Reference No:	2024/62/93548/W
Site Address:	Highfield, Green Cliff, Honley, Holmfirth, HD9 6JN
Description:	Erection of two storey front extension with terrace and associated external alterations (within a Conservation Area)
Recommending Officer:	Molly Storer

HOUSEHOLDER DELEGATED REPORT

Application Number	2024/93548
Location	Highfield, Green Cliff, Honley, Holmfirth, HD9 6JN
Proposal	Erection of two storey front extension with terrace and associated external alterations (within a Conservation Area)
Publicity end date	28 th February 2025
Number of representations received	The proposal was advertised as affecting the setting of Honley Conservation Area via site notice and newspaper advertisement and also advertised via neighbour notification letters. One representation was received which will be discussed within the representations section of the report. An assessment of the impact of the development upon the setting of the Conservation Area is also undertaken in the following report.
Kirklees Local Plan Allocation/Designation	The site is unallocated on the Kirklees Local Plan however is located within the Honley Conservation Area and falls within the Holme Valley Neighbourhood Pl

Drawn	DRH / CJA
Date	August 2023
Scales	1:100 @ A2
Drawing No.	2383 - 0303 - P05

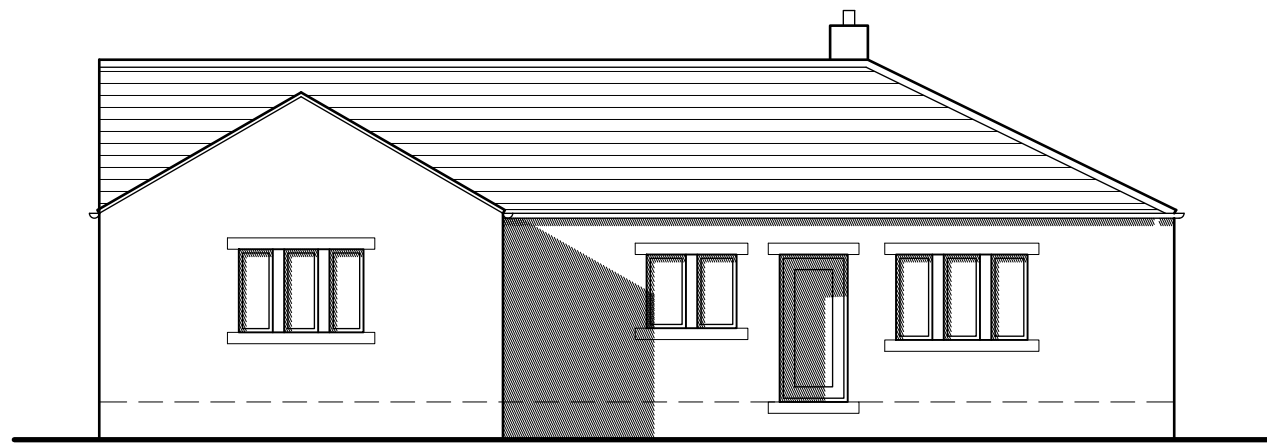
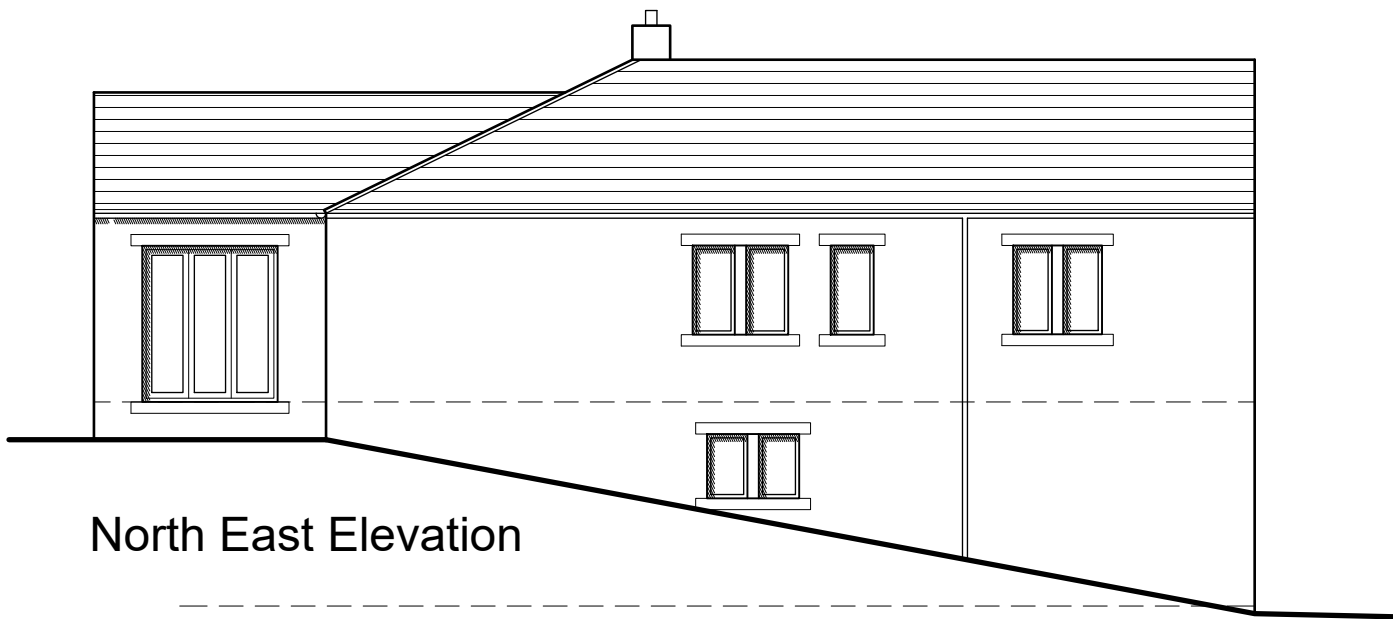
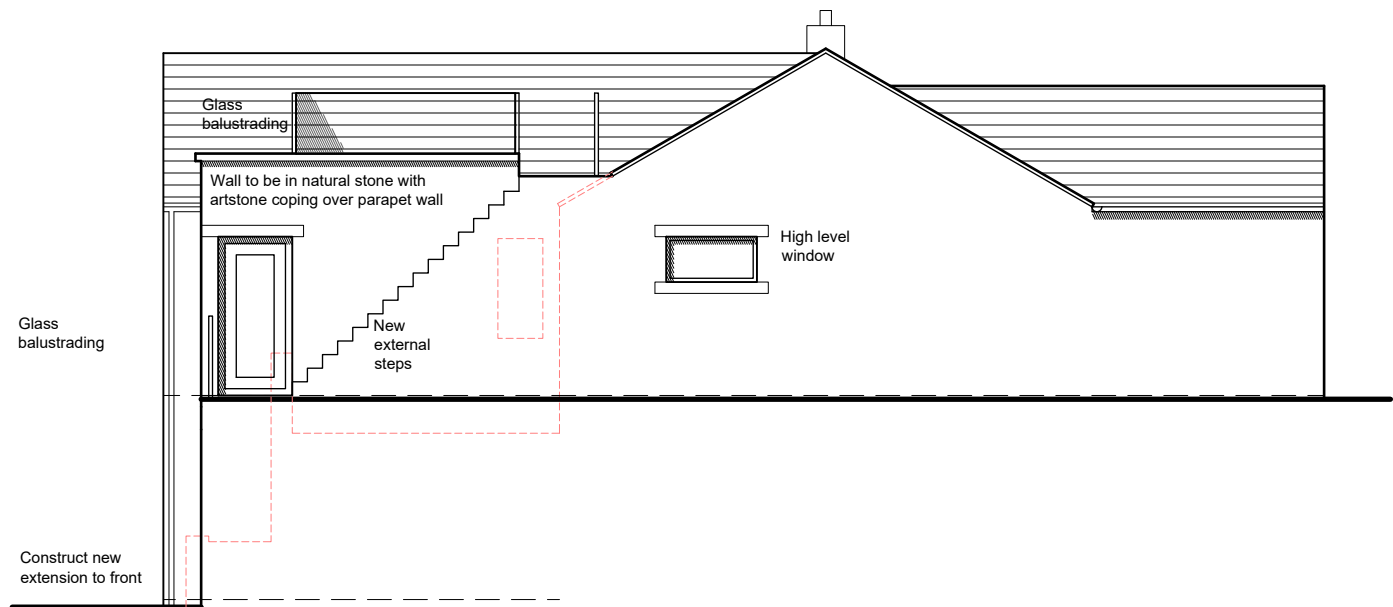
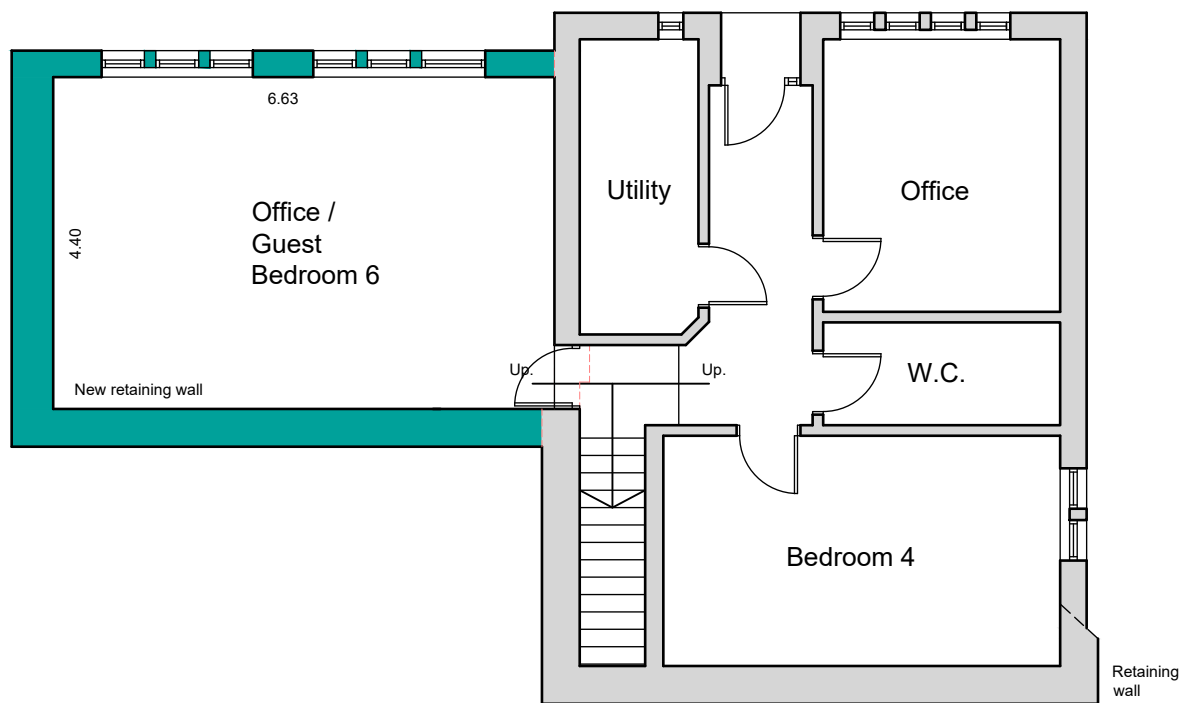
YES / NO	SUMMARY
Negotiations/Amendments during course of application	Yes	The agent was contacted as there were concerns with regards to the original proposal. It was considered that the proposal did not meet the requirements of the SPD. It was suggested that to make the proposal more acceptable

consideration should be given to removing the terrace and external stairs from the scheme due to overlooking issues. The large flat roof addition was also considered to be visually harmful. It was noted that some form of extension could take place at the front of the property however this would need to be sympathetic to the existing dwelling. It was suggested that if the flat roof was resigned to be gable(s) to replicate the existing front elevation and to tie into the original roof this could be more acceptable. It was also suggested that consideration be given to having matching/harmonising openings on the front elevation to those existing as the large extent of glazing detracted from the host property and would be visually harmful. The agent responded with plans showing: - Roof top terraced omitted - Arrangement of the openings to the Kitchen / Dining have been adjusted to reflect the traditional style - Balcony to the front redesigned to be more discrete in design and compliment the building design - Pitched roof added

Parish/Town Council comments sought	Yes	Holme Valley Parish Council: Defer to Kirklees Conservation officers. There is also some concern for potential overlooking and the proposed new windows are out of scale with the old.
Planning History	Yes	2012/91235 - Erection of single storey rear extension (within a

Summary of Representation	Officer response	Addressed ✓ / X / N/A
One objection received. • Light and outlook would be unreasonably affected to habitable window to the front of the neighbouring property.	Amenity to this neighbour has been assessed within the residential amenity section of the report. It should be noted that amended plans show the scheme significantly reduced and the roof terrace from the 2 nd floor has been omitted from the plans. This has been replaced with a subservient balcony which is considered	✓

Roof terrace on the second floor would overlook, overshadow and create undue noise.	to have no significant further impact than the existing situation between the two properties.	
---	---	--
